AW/331/18/DOC

The current application relates to two conditions applied to AW/187/18/PL and relates to the provision of:

- A schedule of materials and finishes and samples of such materials and finishes to be used for external walls and roofs of the proposed extension
- Details of the construction and materials of all new joinery (windows & doors) have been submitted to and approved by the Local Planning Authority

WINDOW SECTION.

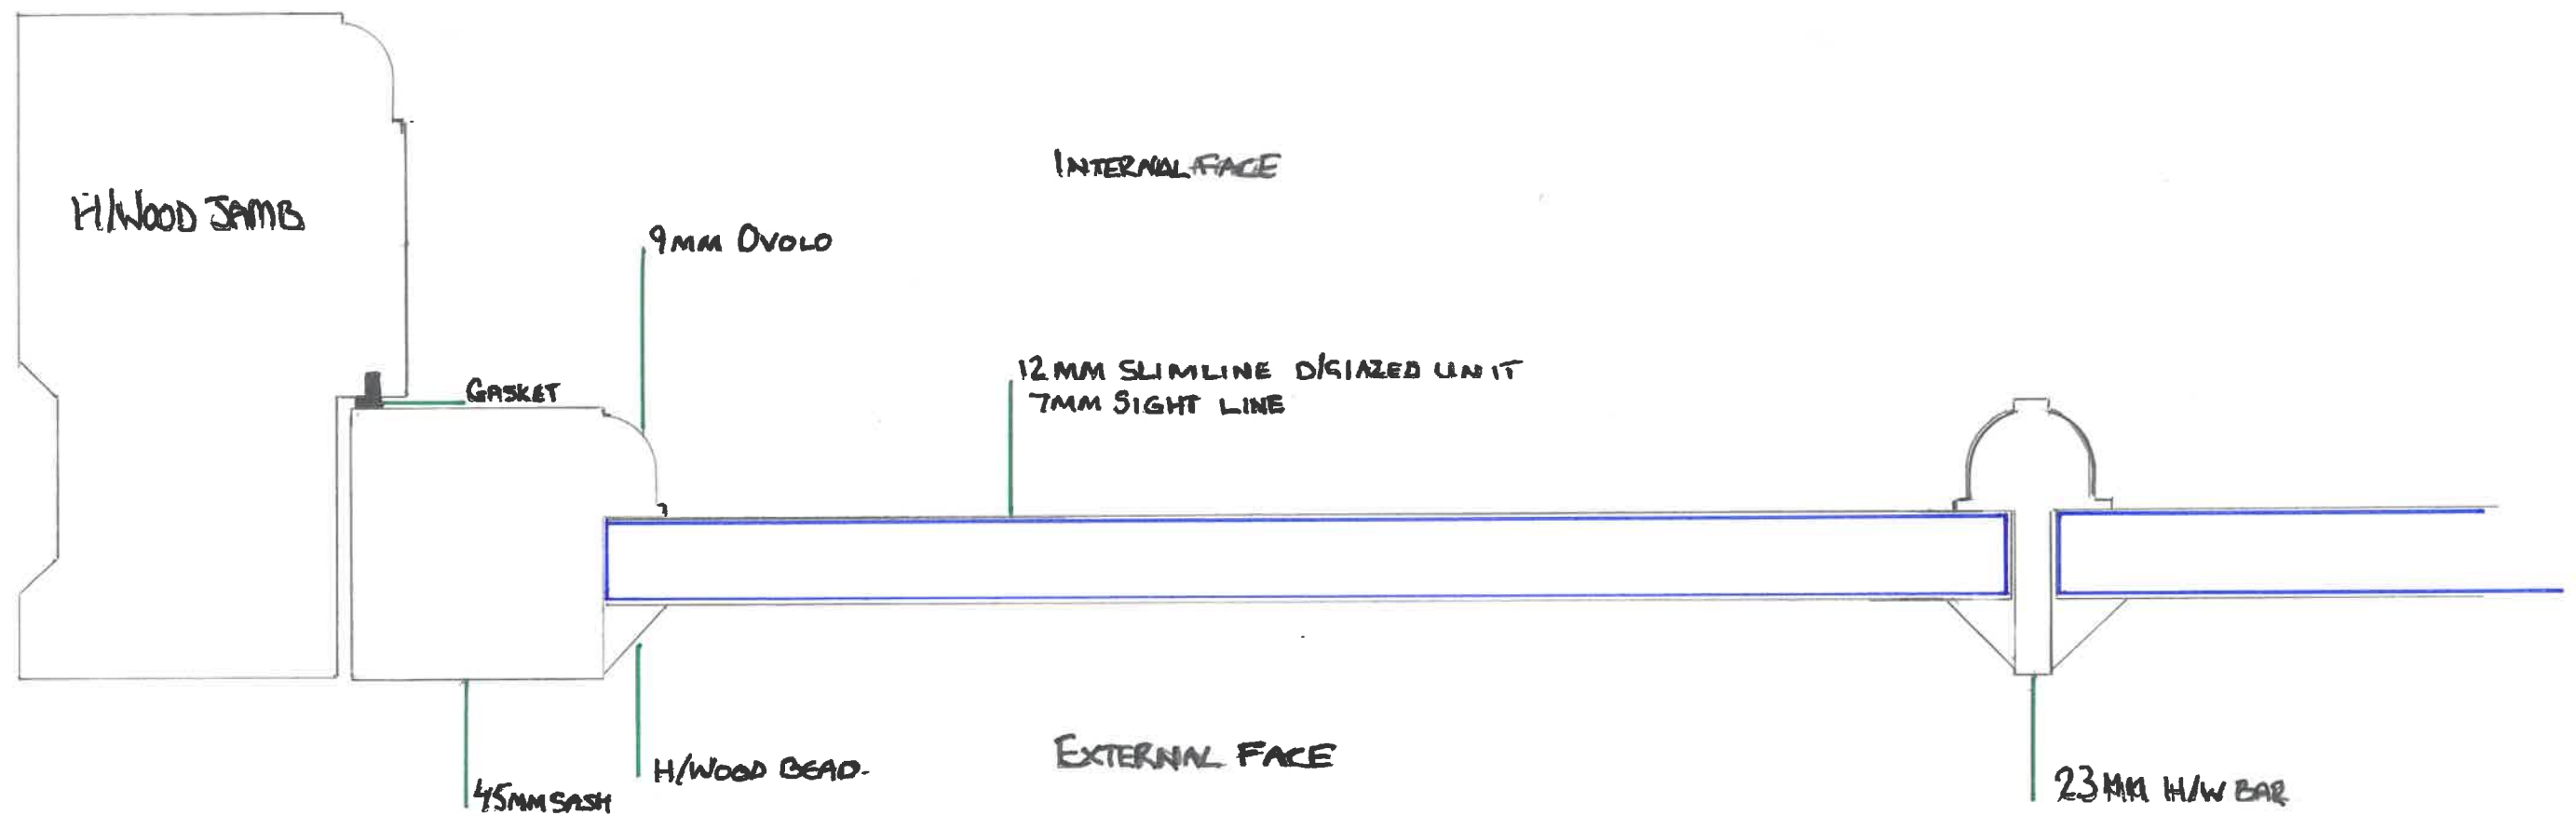
Therefore, I will require alternative sample of the slate as well as scaled drawings/sections of the proposed windows.

With regard to the new joinery, I note that a list of materials has been provided, along with two photographs of similar doors/windows on the existing property. Reference to the use of hardwood is acceptable, as is the colour (white). However, as only two photographs have been provided, as opposed to some form of scaled drawing indicating measurements, it is not clear if the proposed windows will be a true like-for-like copy, or merely similar in appearance. It is considered that some greater certainty would be required.

Thank you for your recent e mail. We have arranged for the joinery company to supply some section drawings of the windows as requested and we are in the process of looking at an alternative slate for the roof. We will now opt for something that closely matches the roof of the house and is of a natural material.
